CITY OF ALBUQUERQUE

OFFICIAL NOTIFICATION OF DECISION

Project# 1005354
16EPC-40059 Amend Site Development Plan for
Building Permit
16EPC 40060 Amend Site Development Plan for
Subdivision

CONDITIONS OF APPROVAL: 16EPC-40059, Site Development Plan for Building Permit:

EXTERIOR  
ELEVATIONS

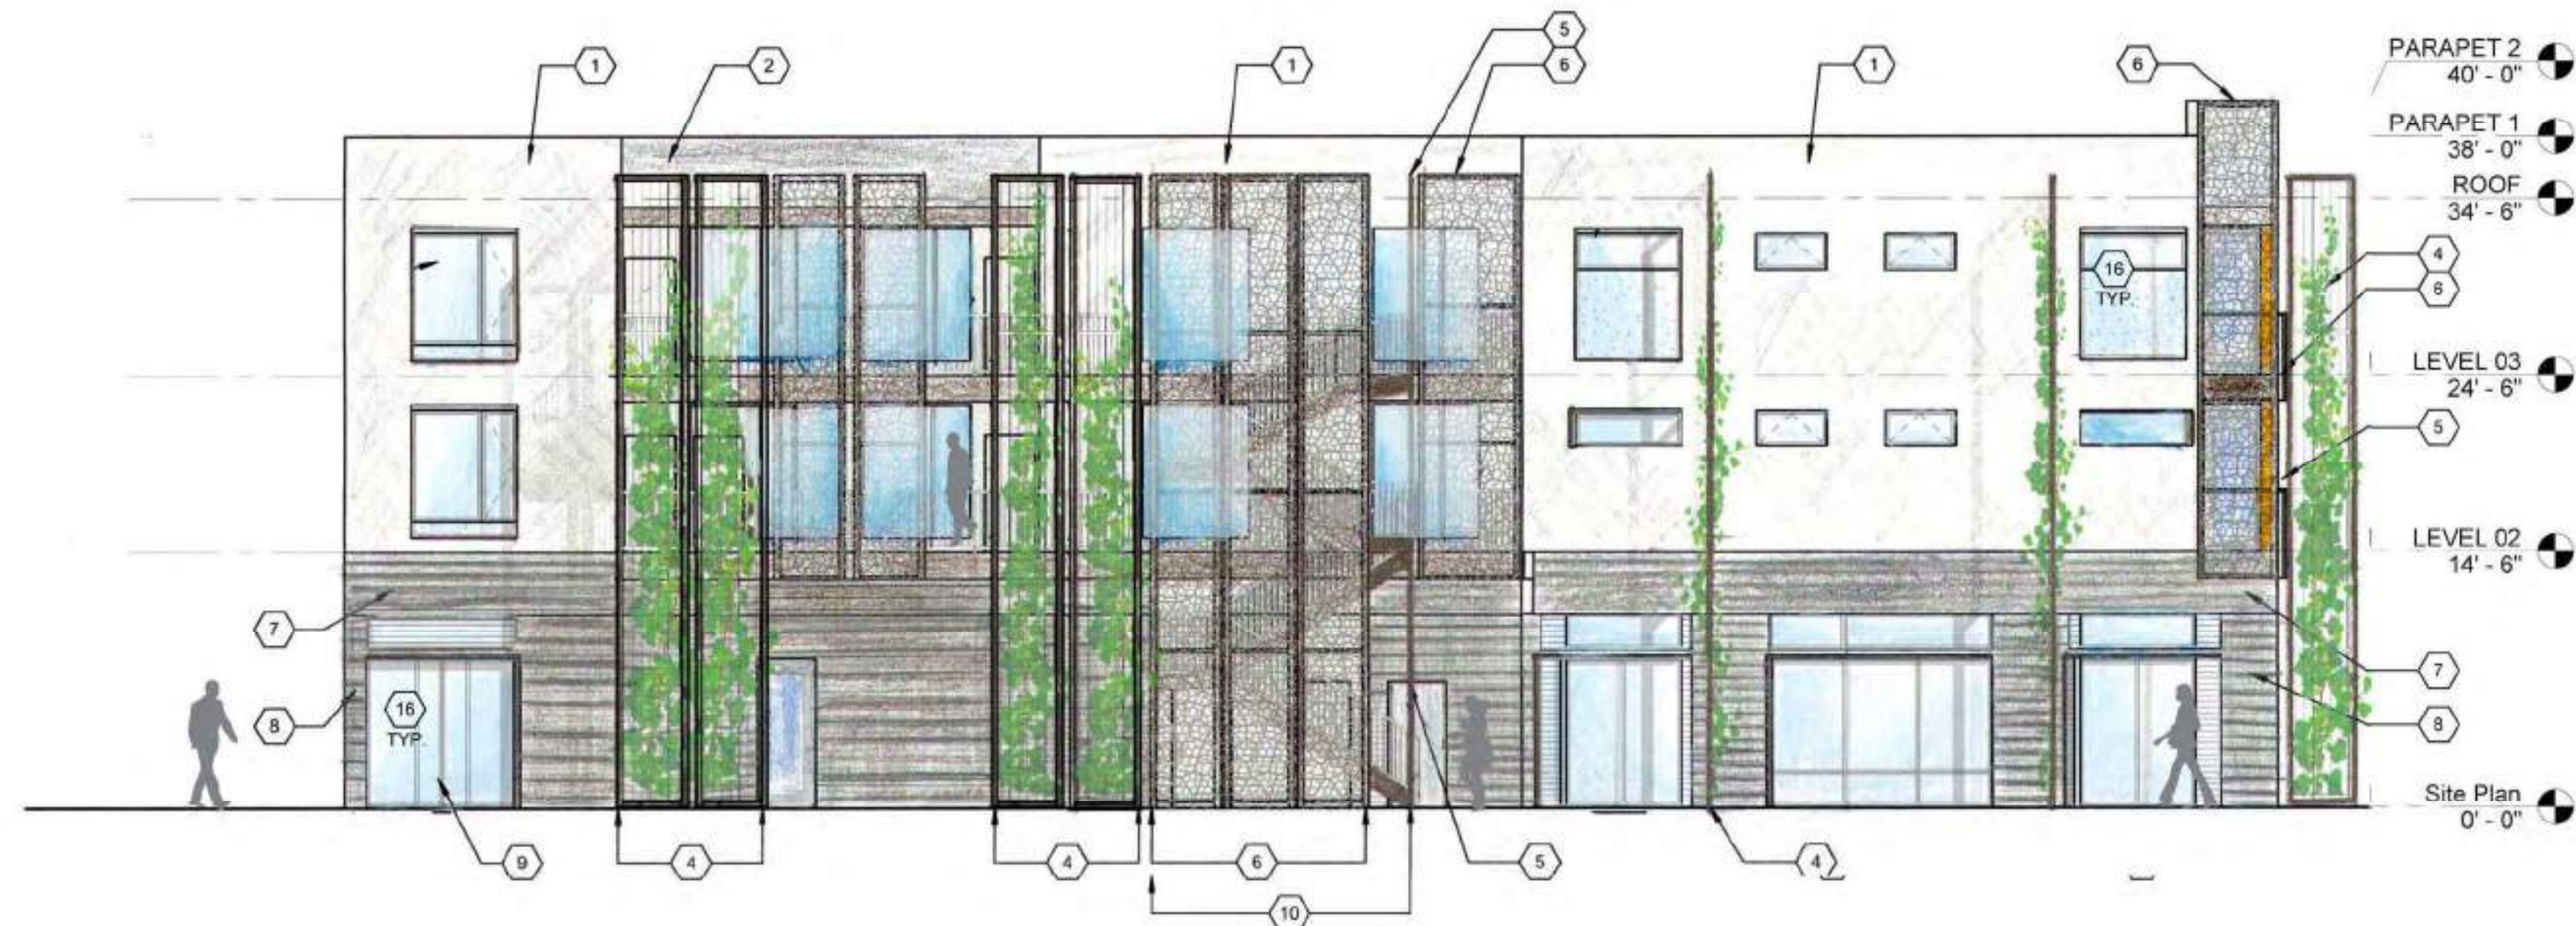
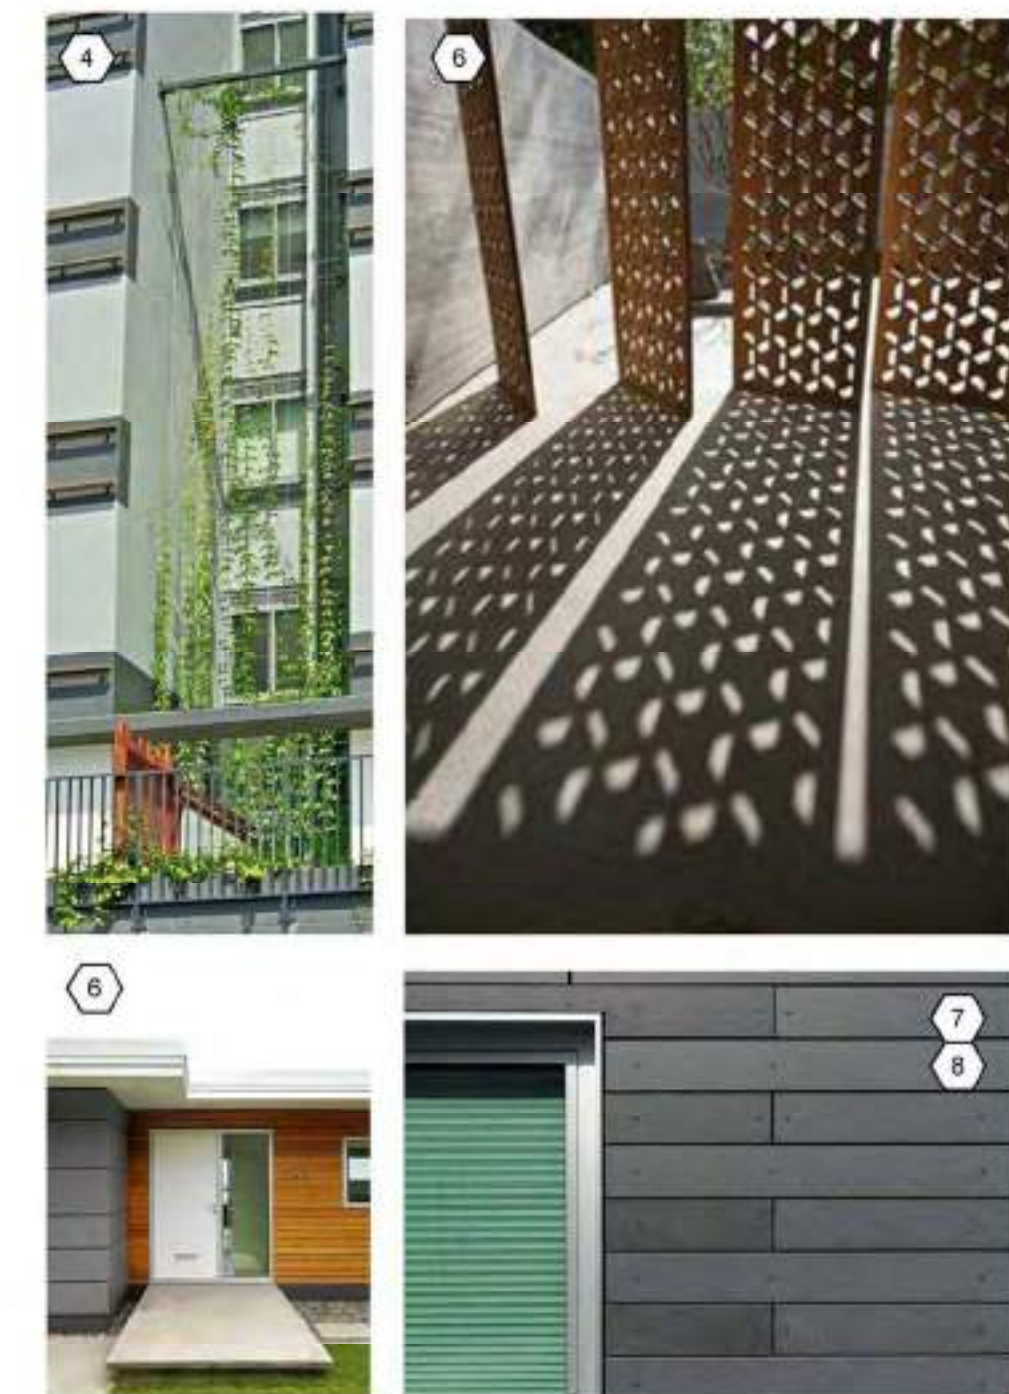
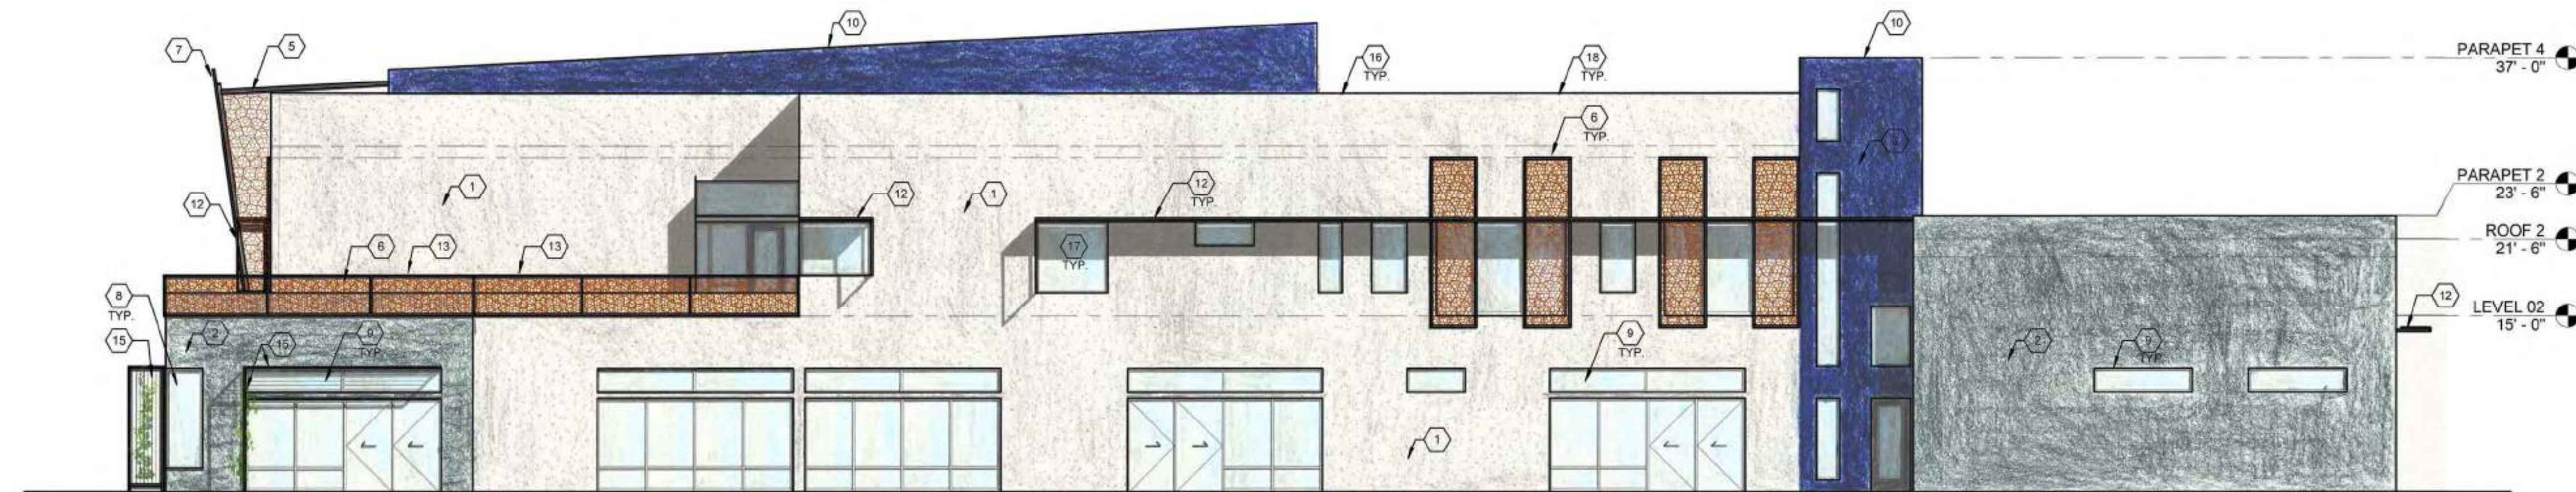
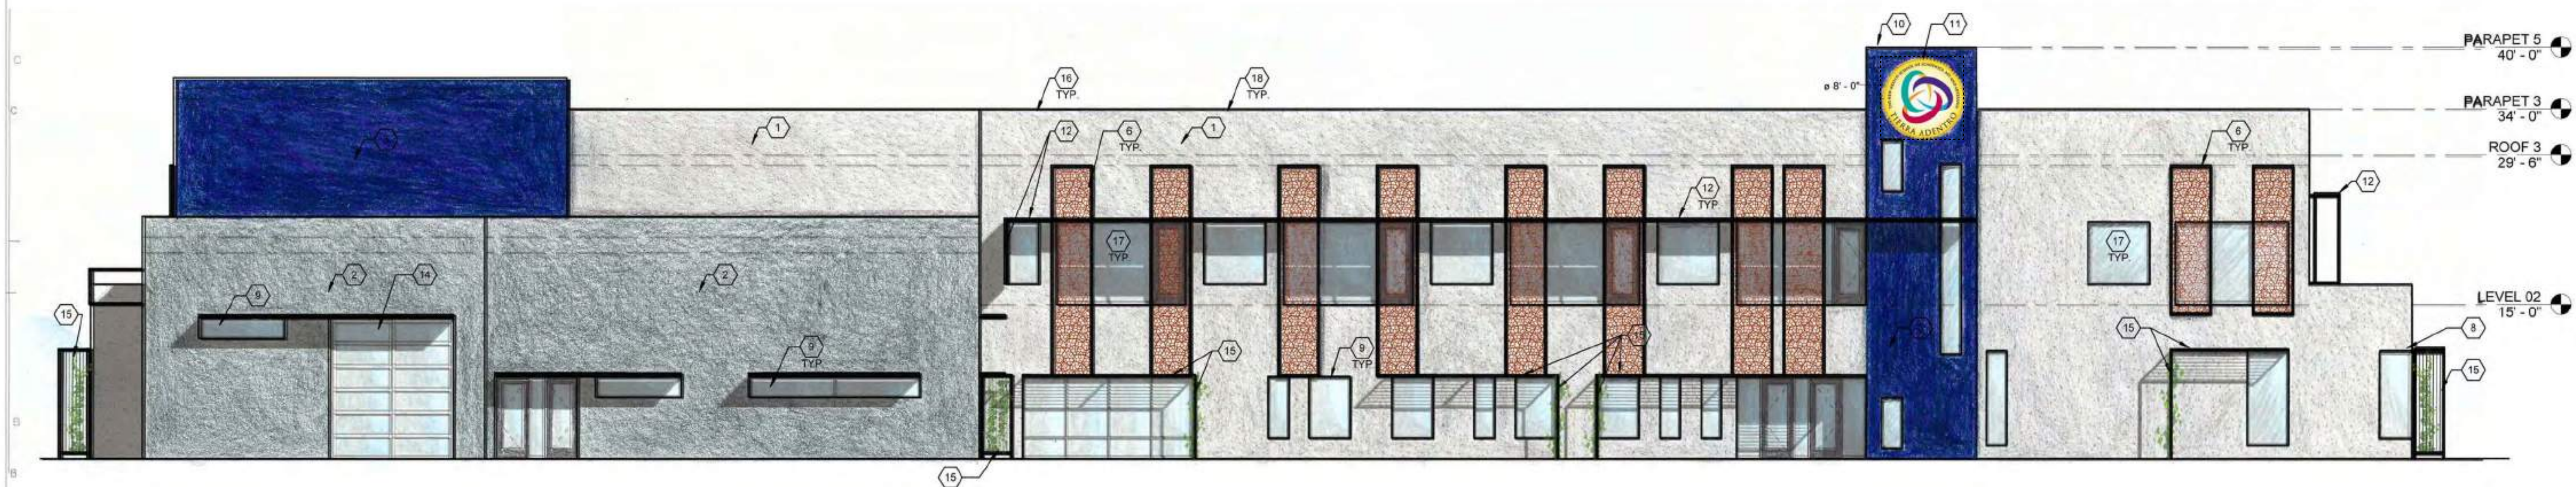
4. SWPSDP General SU-2 Regulations.
 - A. A note shall be added to the elevations to indicate that mechanical and electrical equipment shall be screened from public view (Regulation 4.d).

- B. A note shall be added to the elevations to indicate that reflective glass is prohibited (Regulation 4.e).
5. Parking:
 - A. The parking space counts for the approximately 10-acre site shall be verified and the Parking Table(s) shall be updated correspondingly.
